FROM: Jodie Wilkes TO: Arun District Council
FAO: Mr D Easton

SUBJECT: A/75/17/PL- 5 No. Dwellings. This application affects the setting of a Listed Building and is a departure from the Development Plan

Avenals Farm, Water Lane, Angmering, West Sussex, BN16 4EP

PROPOSED ROOF PLAN & SHED DRAWING
SCALE 1:100 AT A3

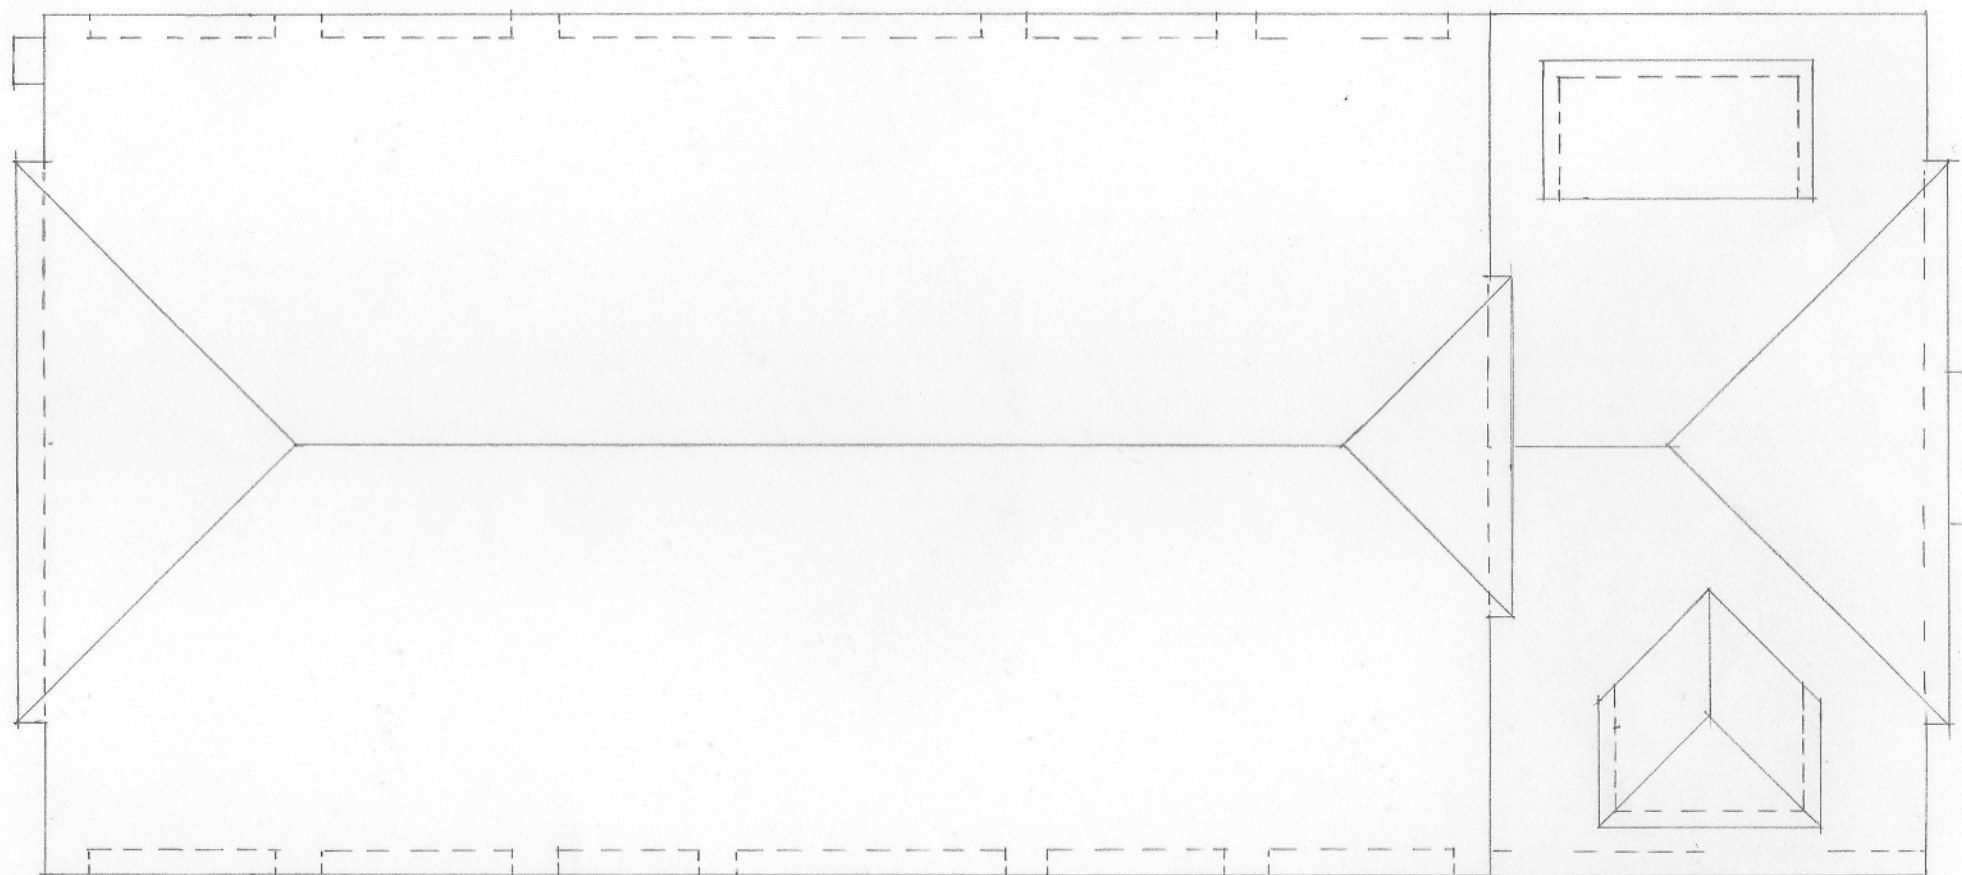
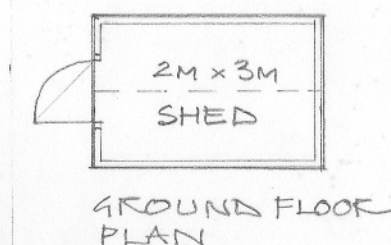
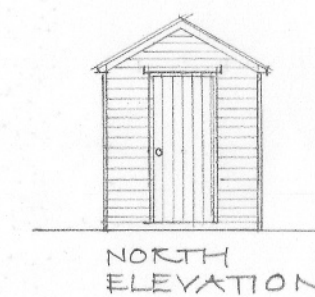
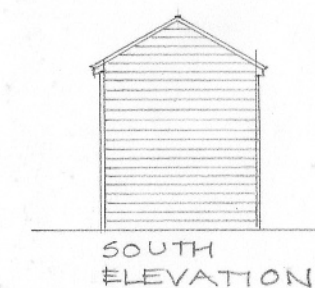
provision is anticipated to satisfy the likely demands. The vehicular parking spaces should measure 2.4m x 4.8m in order to suitably accommodate an average size vehicle. The LHA also support the proposals to include a shed building which may be utilised as secure covered cycle parking for the new dwelling.

No part of the development shall be first occupied until covered and secure cycle parking spaces have been provided in accordance with plans and details submitted to and approved by the Local Planning Authority.
